Ref No: Pre-app advice
Officer: Kelly Holt

Date: 17th May 2021

PRE-APPLICATION ADVICE

Duke of York Inn, Brow Top - Grindleton Brow, Grindleton, BB7 4QR

PROPOSED SITE PLAN SCALE 1:200

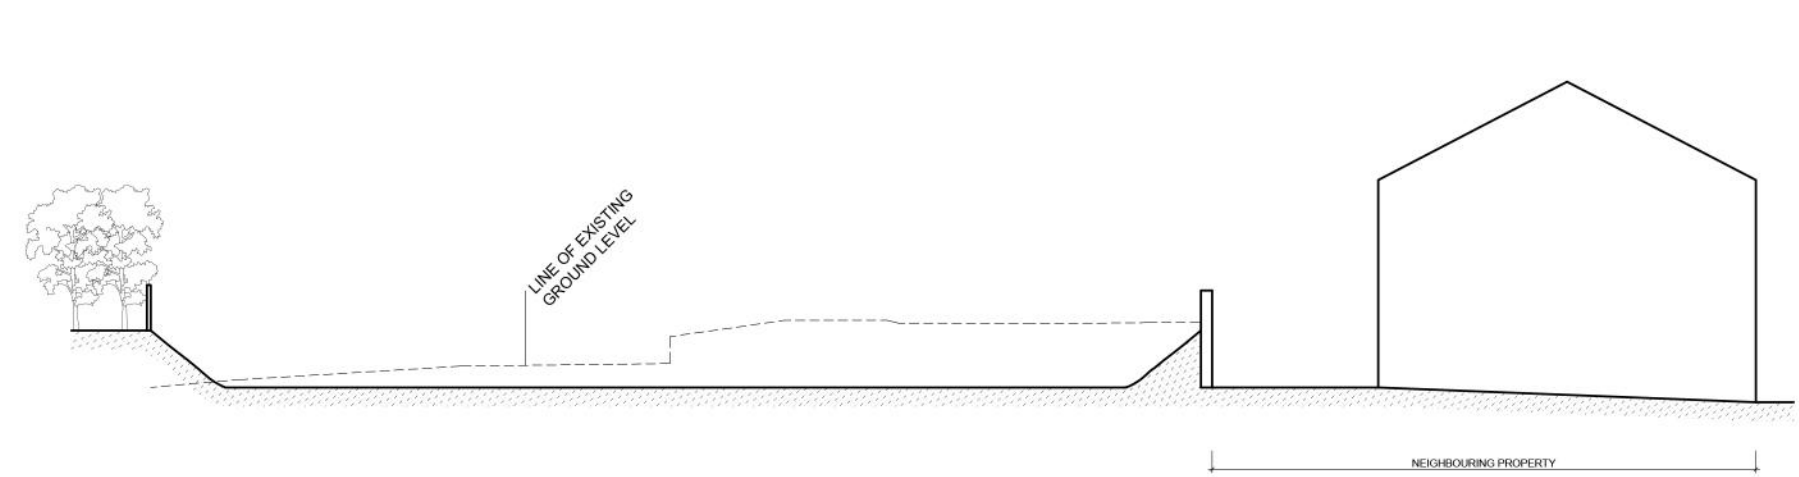
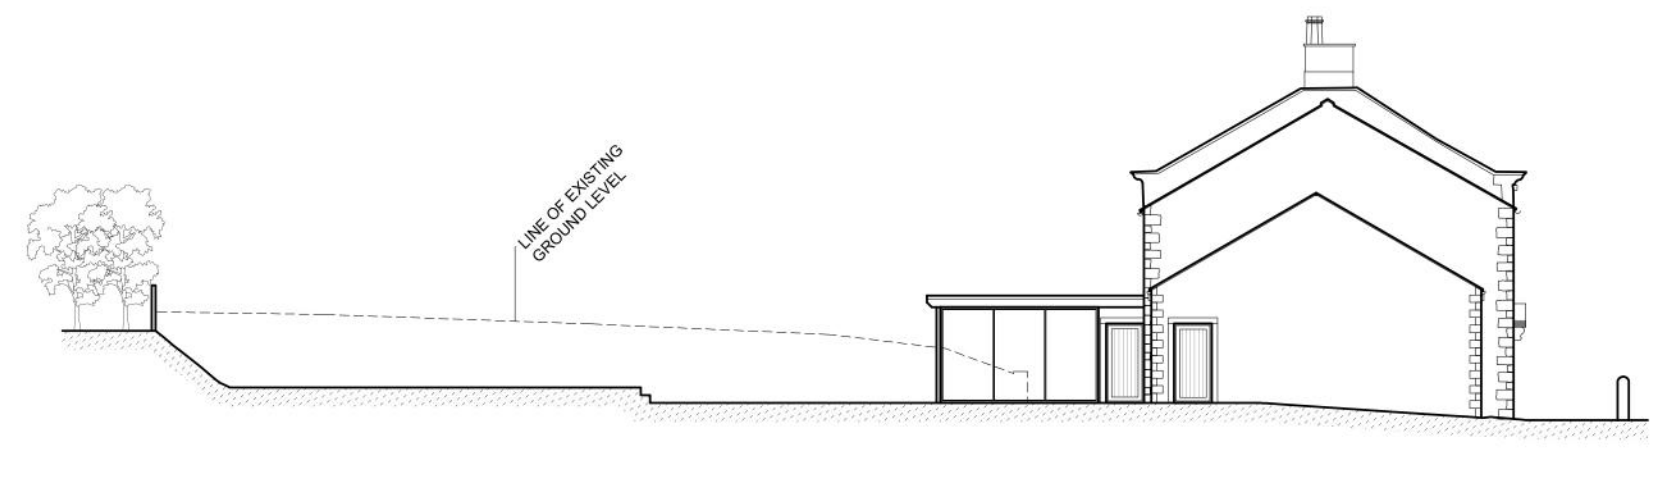
There is a new footway proposed along the frontage of the development site and Grindleton Brow. The site access is to be altered and moved slightly south-westerly with a new radius kerbed arrangement. A minor amendment is requested to provide a footway around the radii on the south side of the site access to join the hardstanding at the side of parking bay 15. This allows a continuous route for pedestrians to exit the site and avoids any conflict arising between pedestrians and vehicles entering the site.

The site access on Grindleton Brow shall have visibility splays of 43m in both directions on Sawley Road/Grindleton Brow for 43m to the nearside kerb, at a distance set back from the give way of 2.4m. This should be shown on the proposed site layout drawing. These splays appear to lie within land within the control of the applicant or the adopted highway.

The boundary wall will need to be constructed below 1m height where it crosses the splay.

The external seating may need adjusting northwards to ensue that it does not lie within the splay and obscure the drivers view.

A swept path analysis for the refuse and largest delivery goods vehicle should be provided to demonstrate that sufficient space is provided within the car park turning area and all vehicles can enter and exit onto Grindleton Brow in forward gear.

1. Provide additional information to support the reduction in car parking provision for the PH.
2. Cycle storage should be provided for guests.
3. Minor amendment to provide continuous footway around radii on south side of site access.
4. Swept path analysis for the refuse/delivery vehicle to show vehicles entering, turning and exiting onto Grindleton Brow in forward gear.
